Memorandum: SER Memo #1

Project: Duke Energy – New Weld Shop  
Pier Question  
MEPC#: 115-24

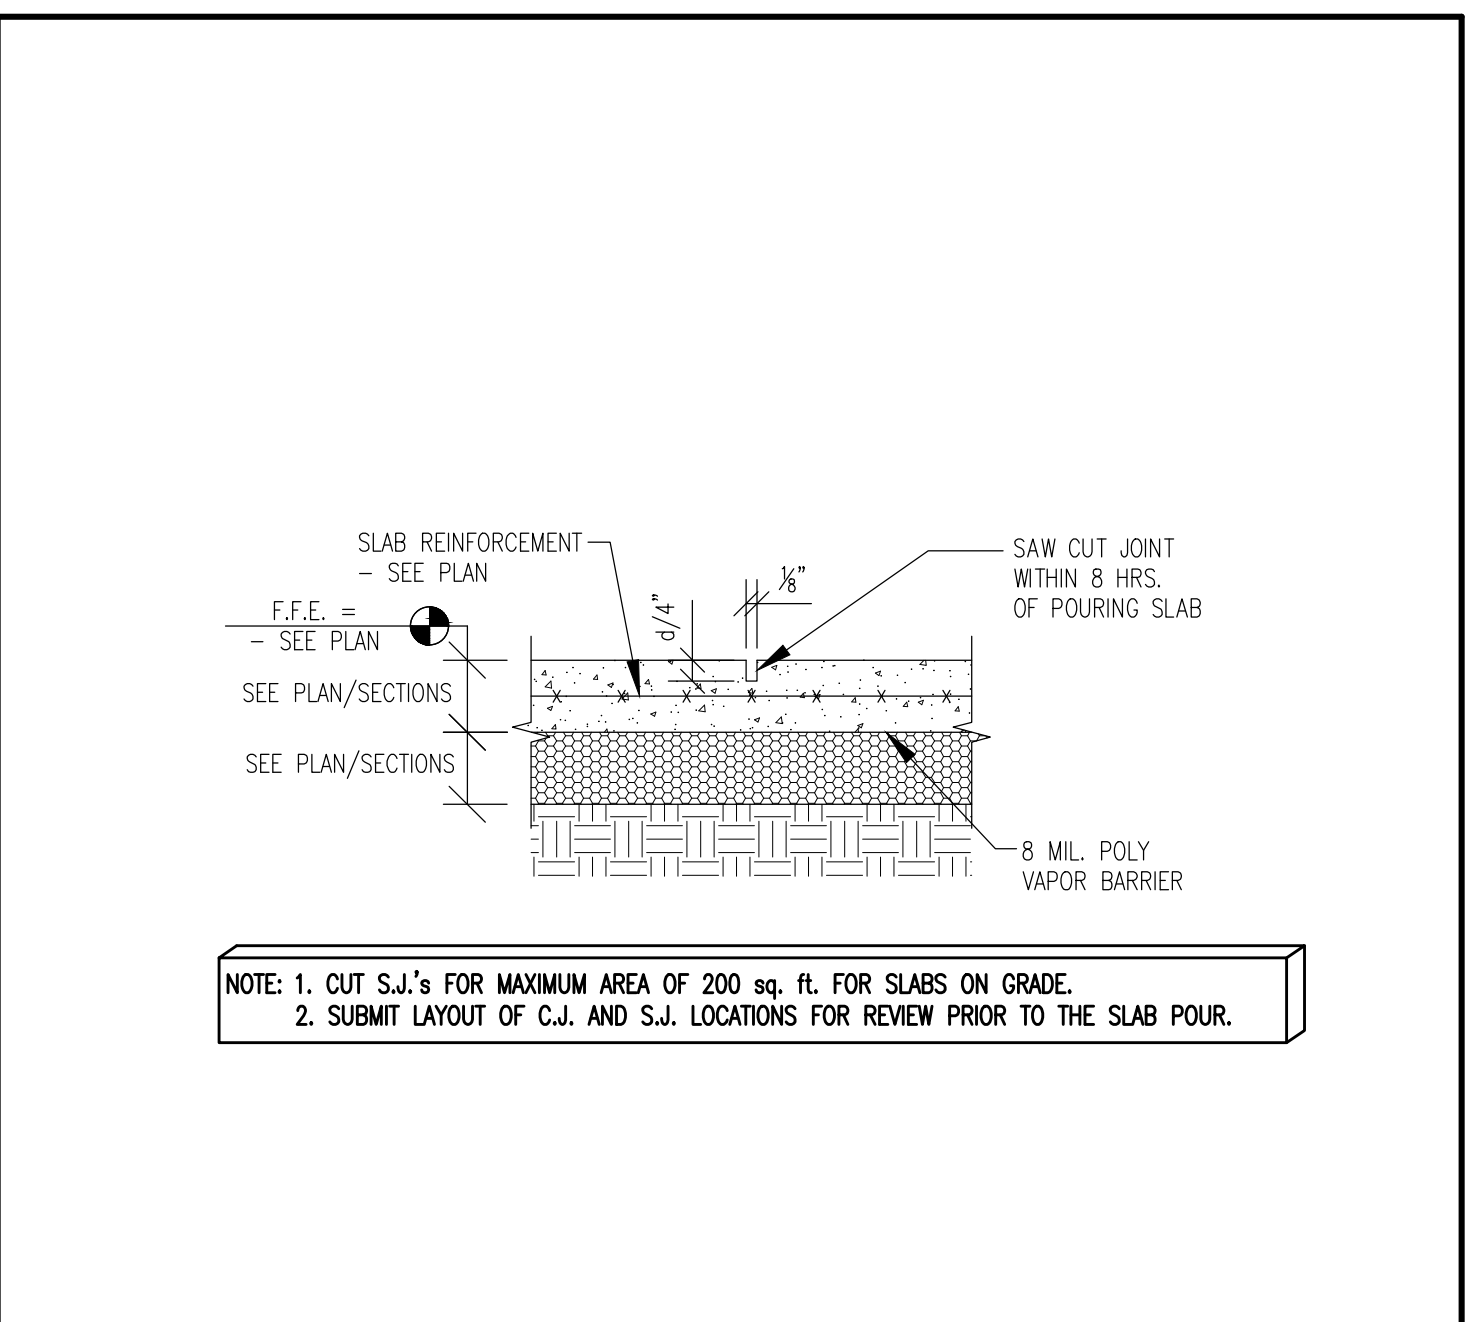
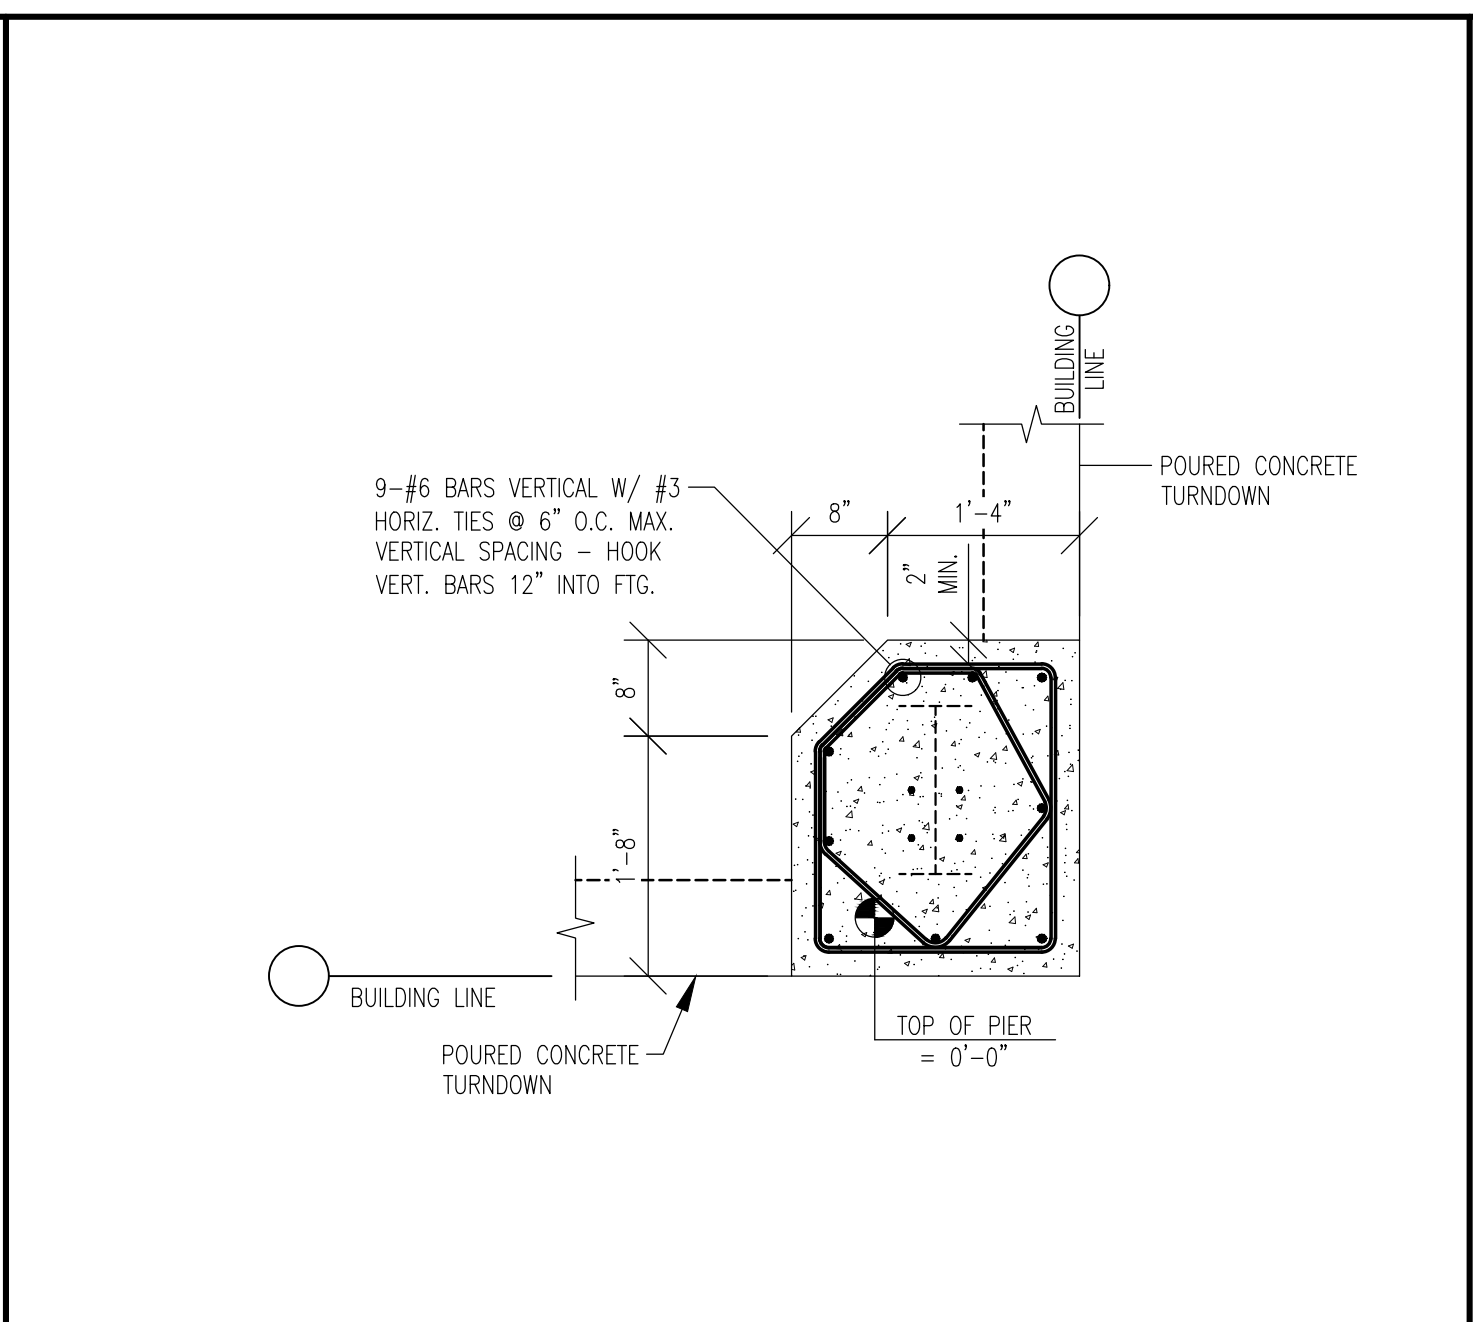
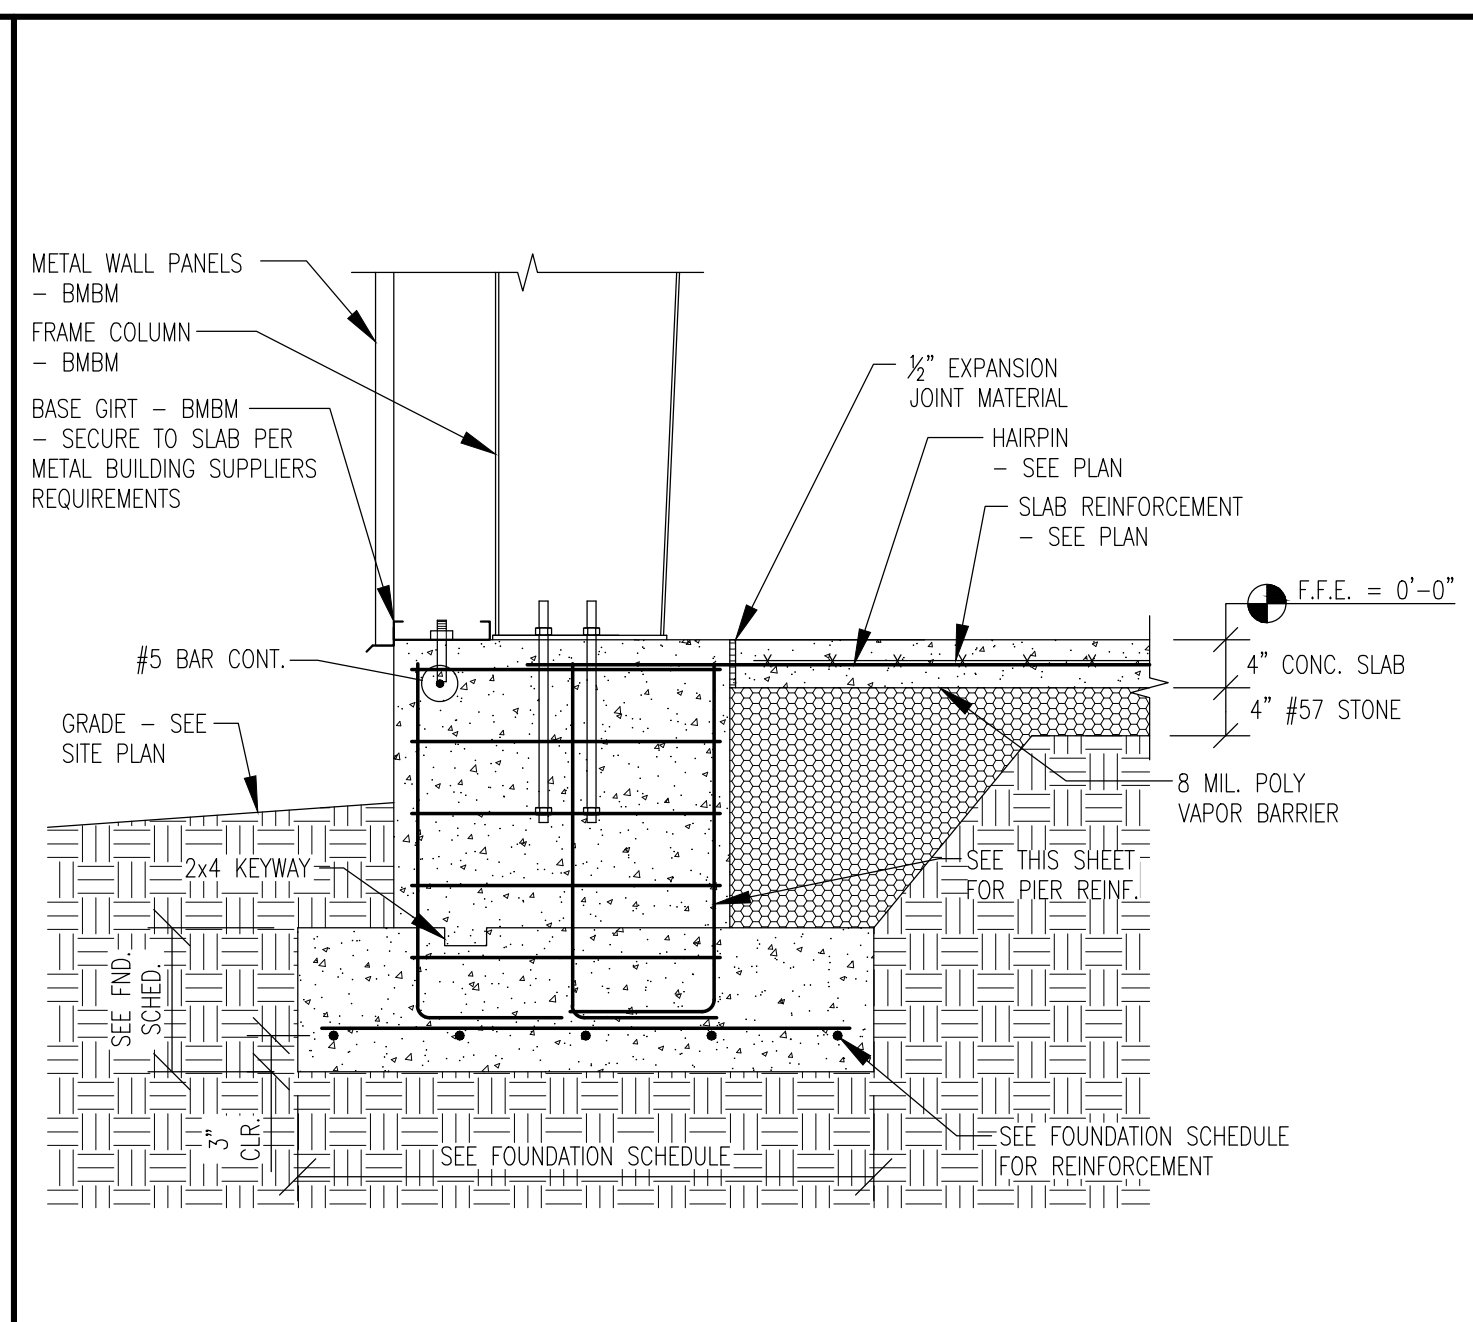
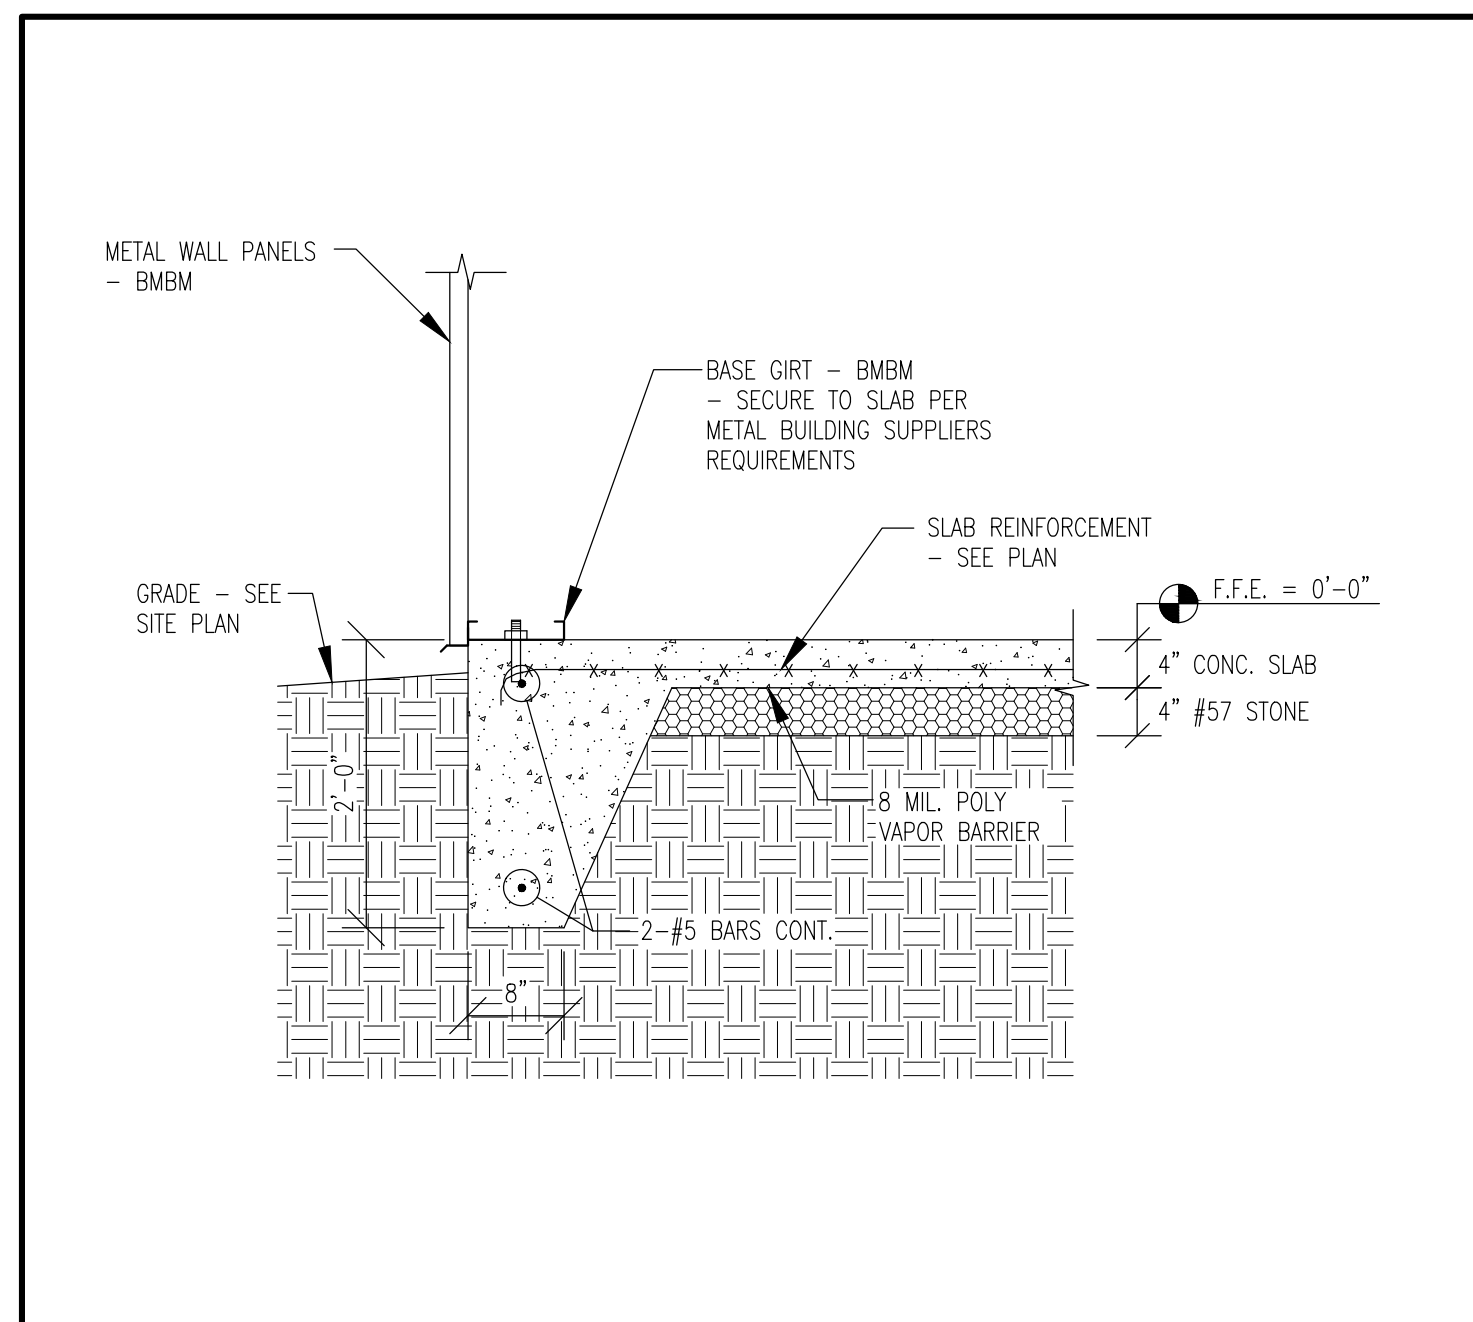
It is our understanding the slab on grade will be poured monolithically with the pier pours. The notations made on Section 2S-301 to eliminate the key way shown in the bottom of the pier at footing interface was an inaccurate representation on the plans for this condition and the key way is not required. If the pier and slab are being poured as a monolithic condition this will also eliminate the need for the ½" expansion joint material between the pier and slab interface.
